Department of Planning, Industry and Environment,
Major Projects

Re: Development Applications SSD 8924
The new Sydney Fish Market - Concept and Stage 1

I object to the development as proposed on the following grounds:

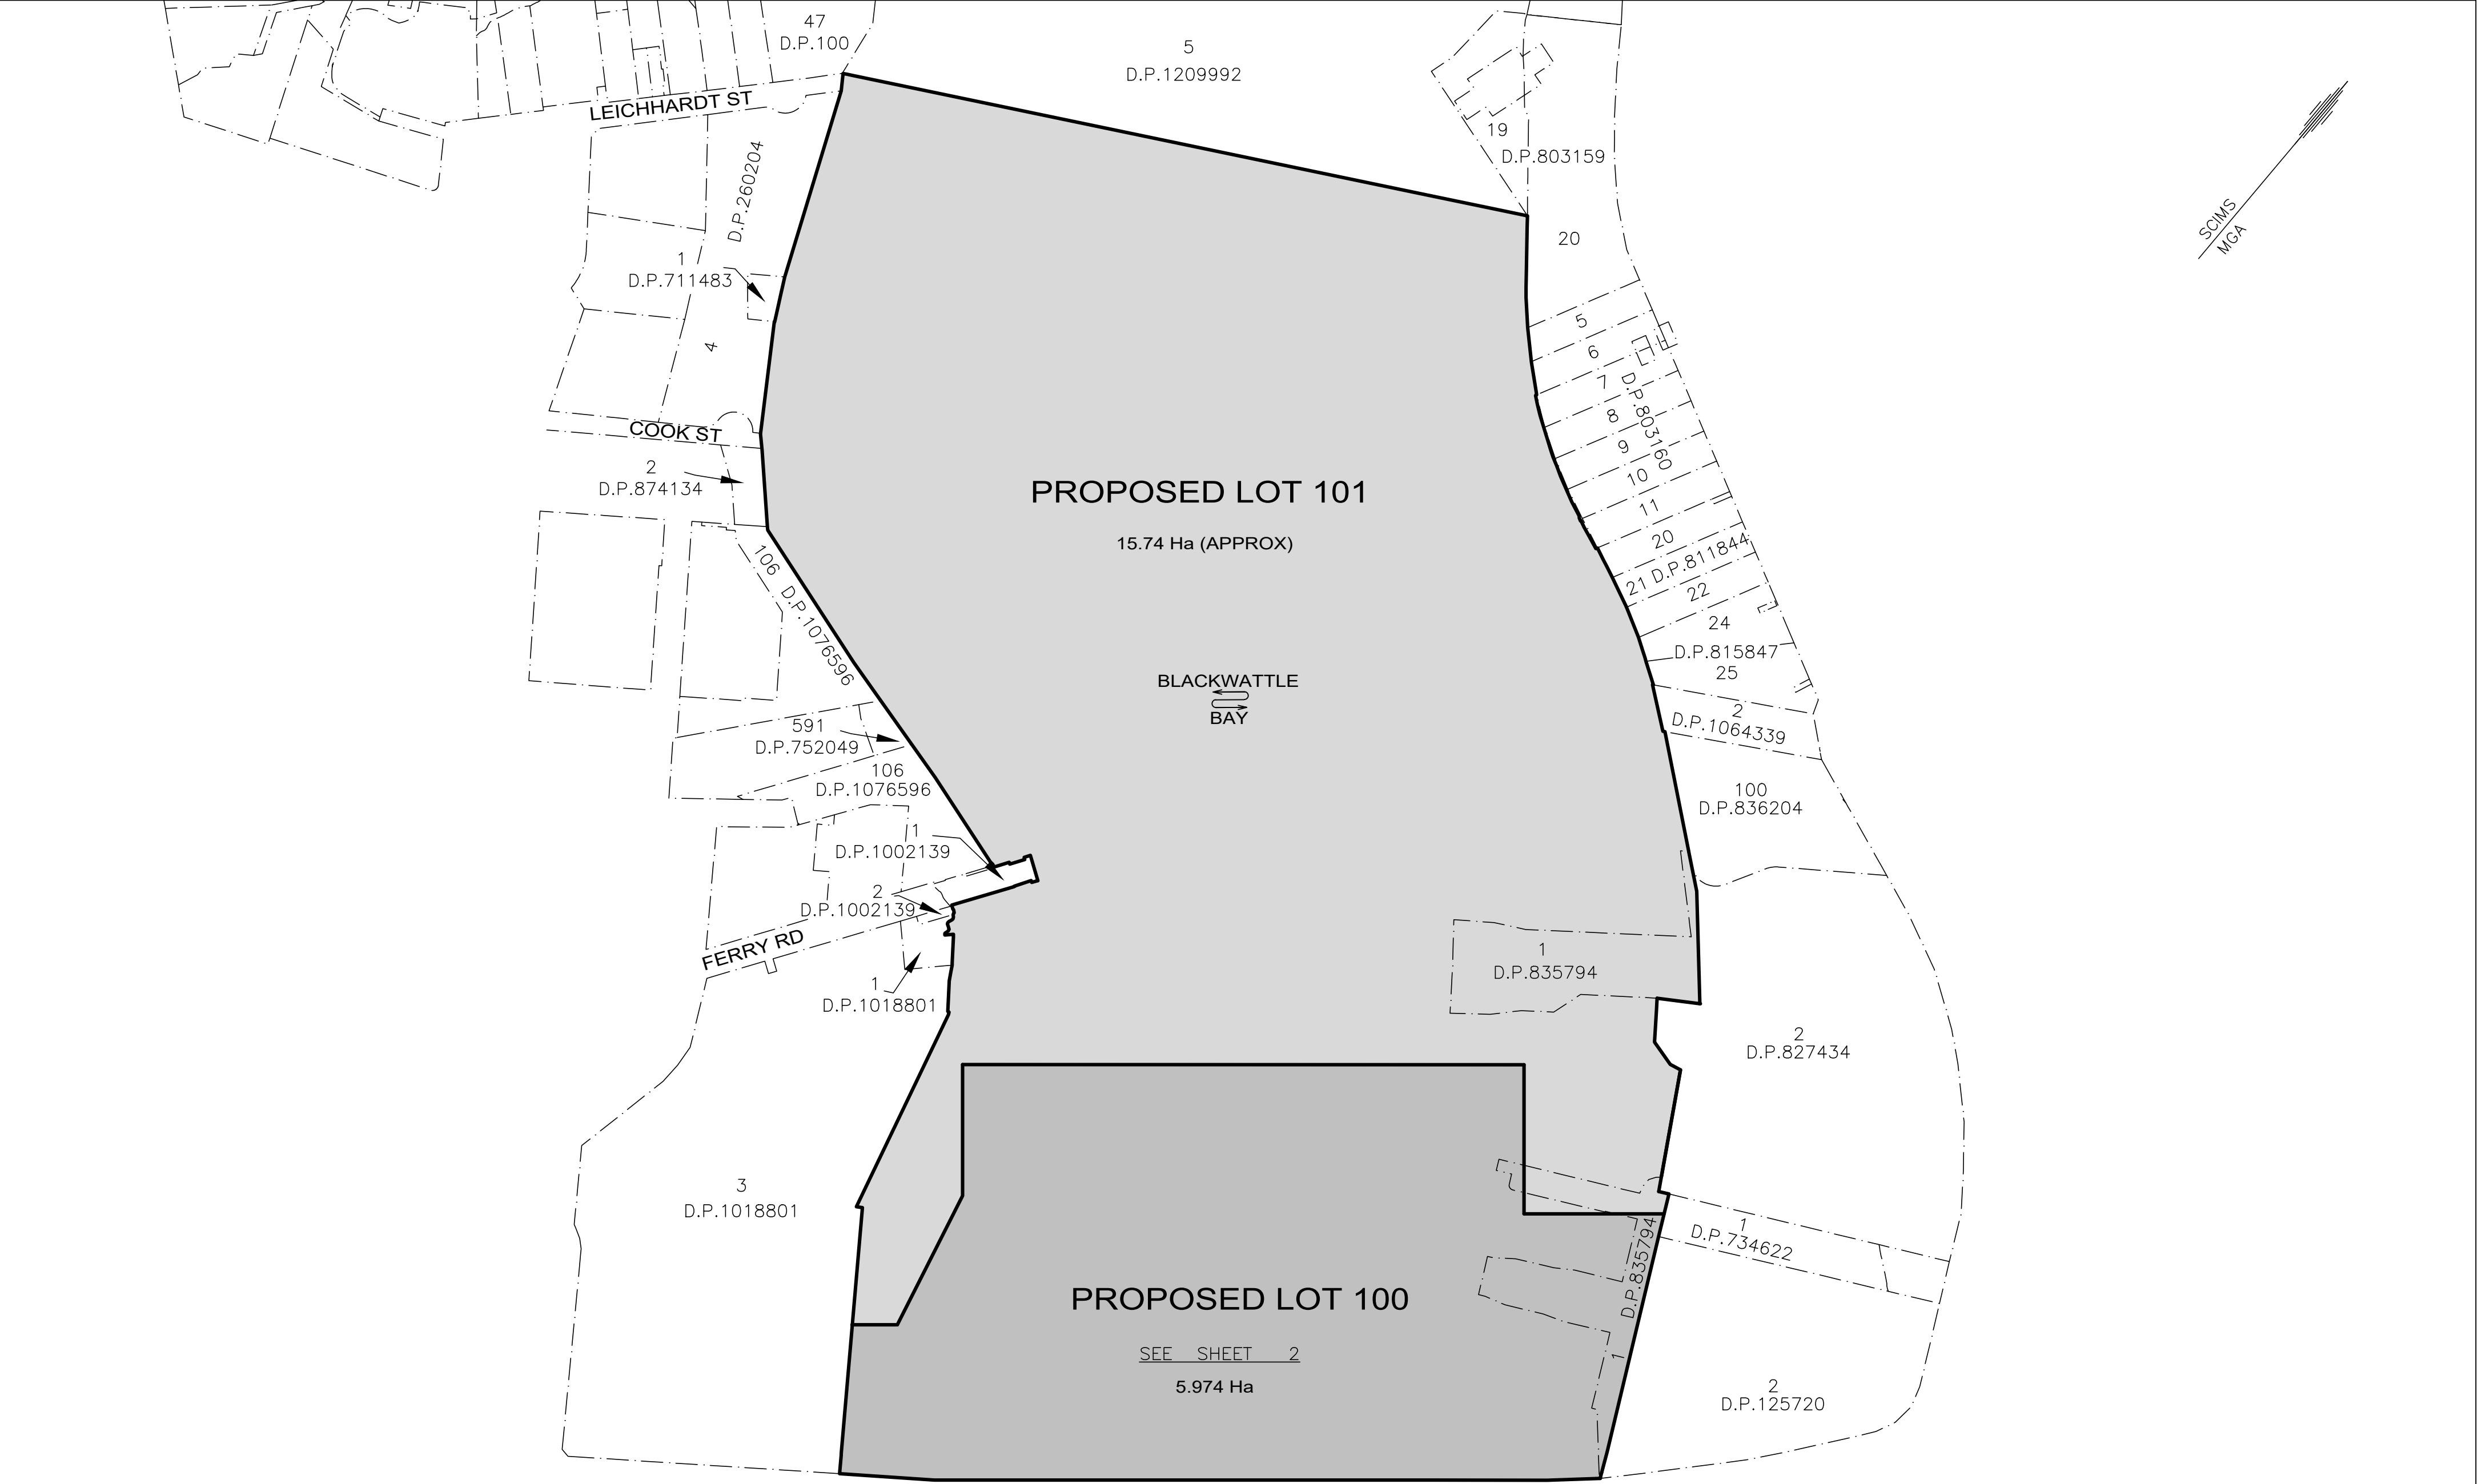
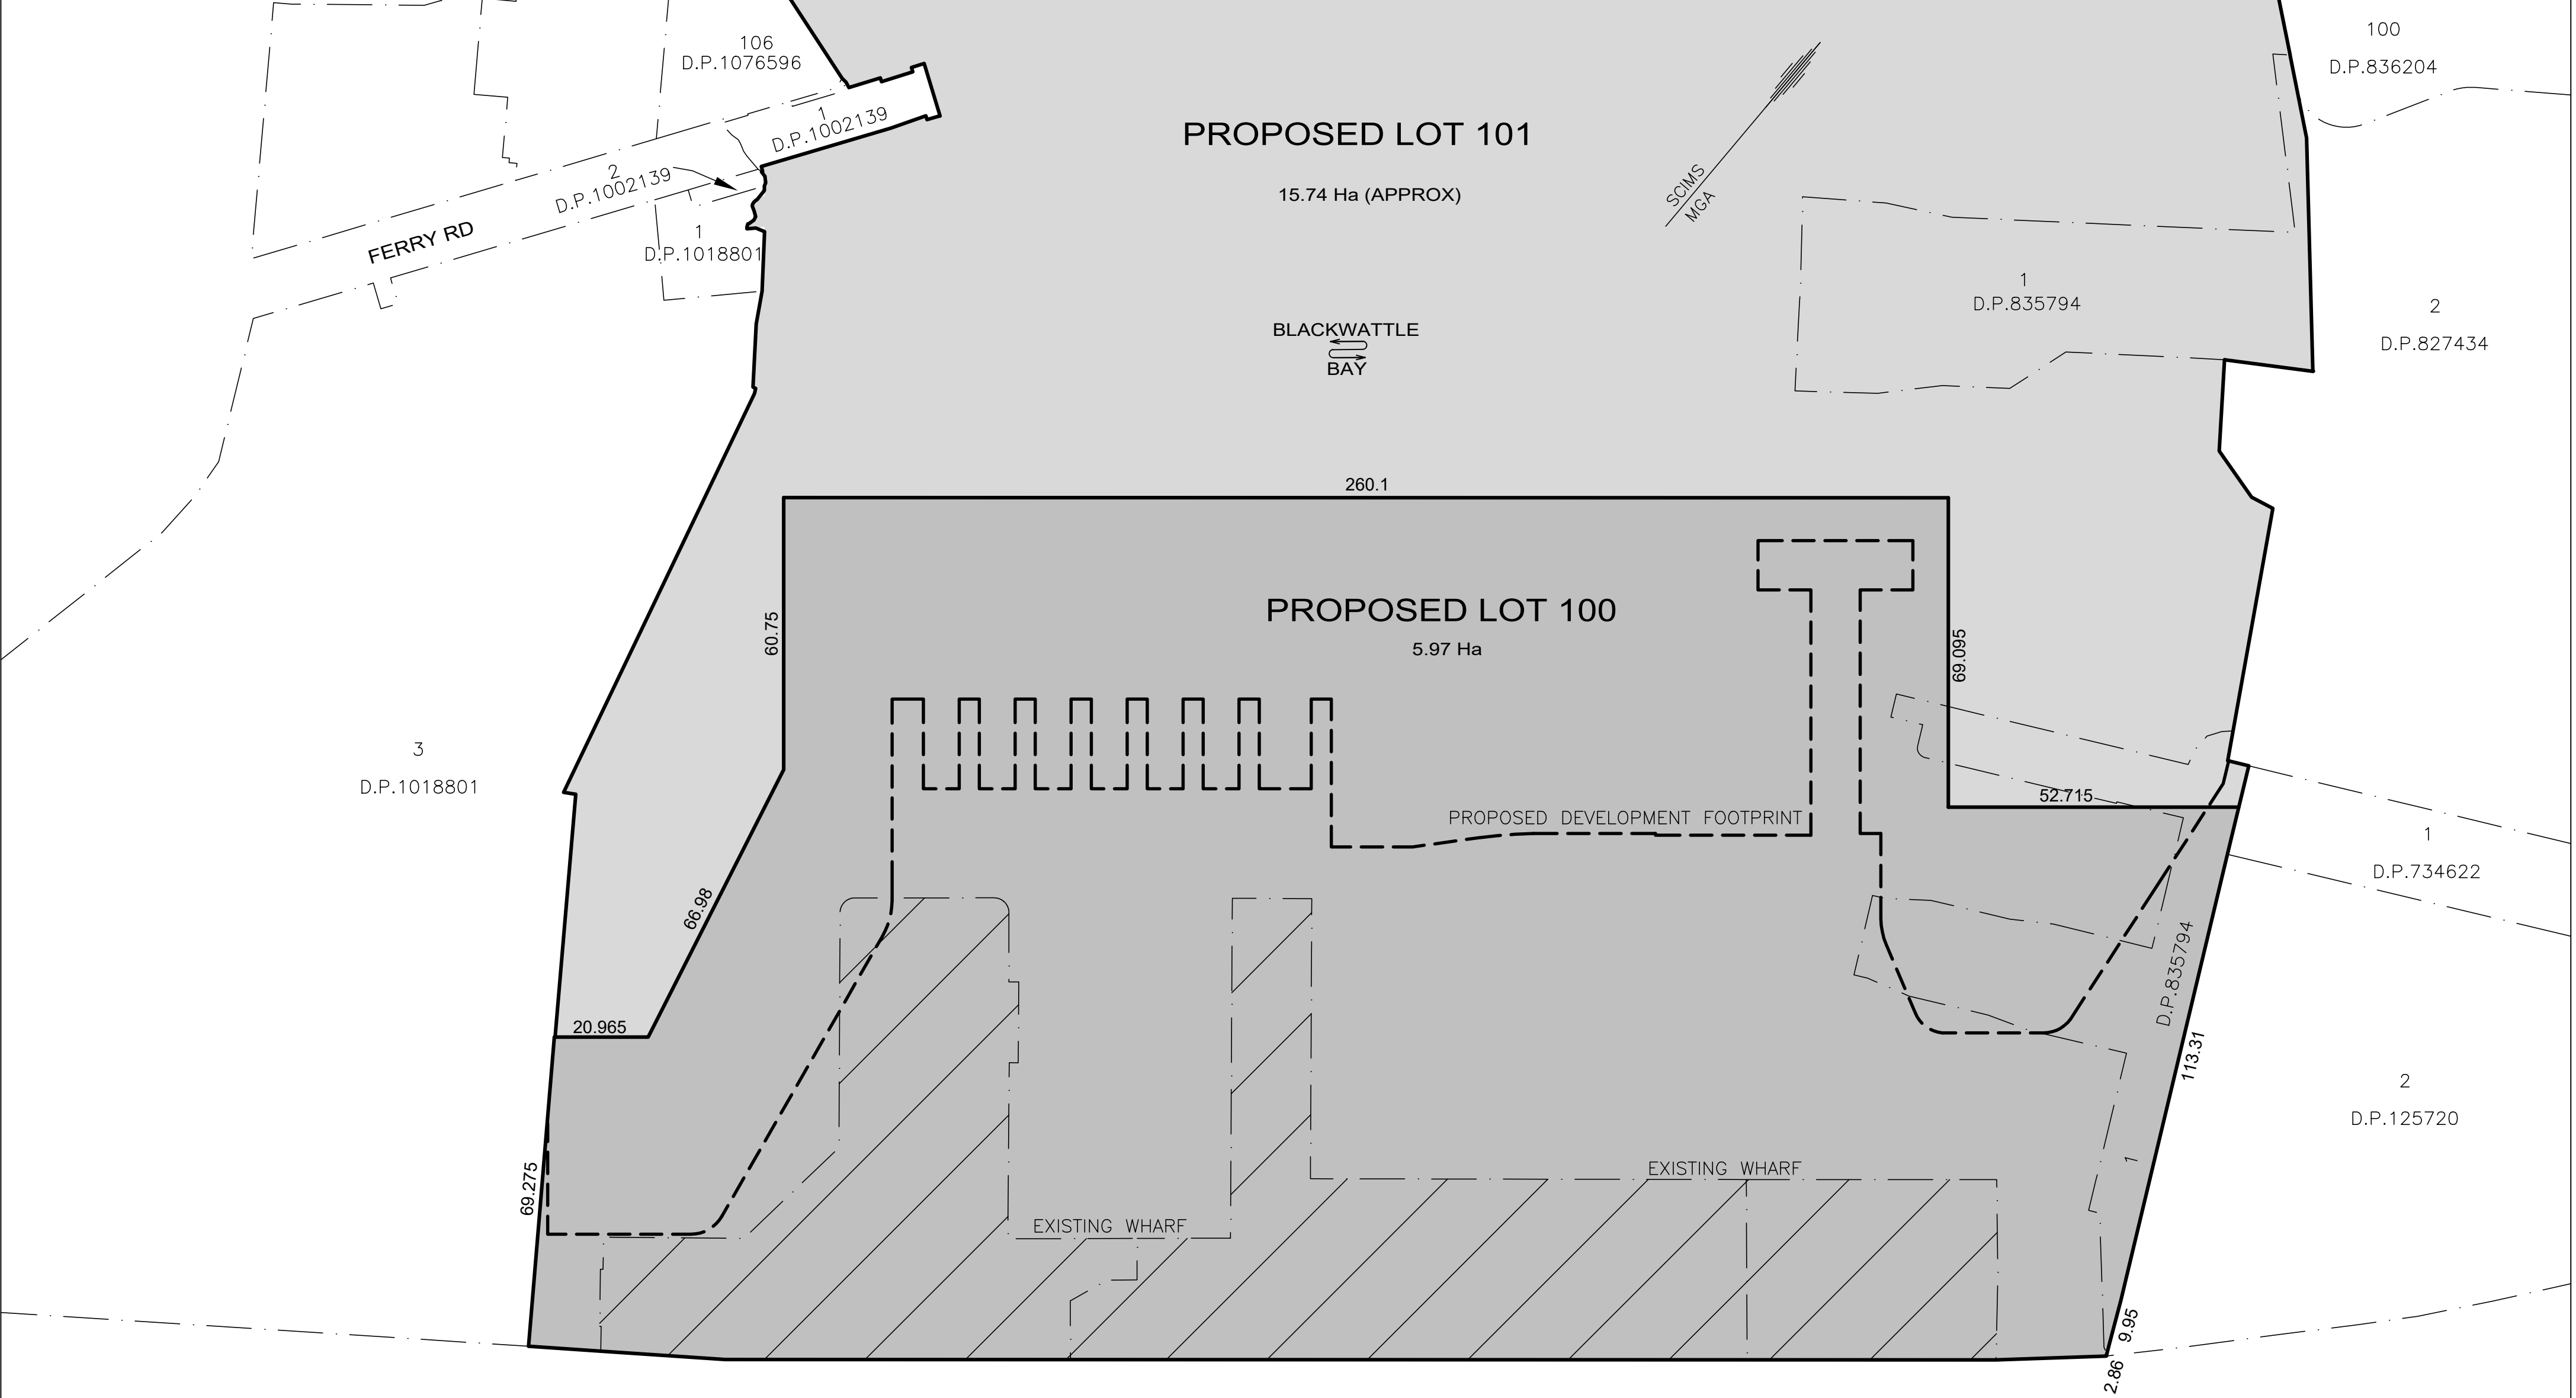
Size and bulk The footprint of the building is huge jutting into Blackwattle Bay over 110 m. (see *Plan of Subdivision of proposed lot 101, sheet 1 of 7*).
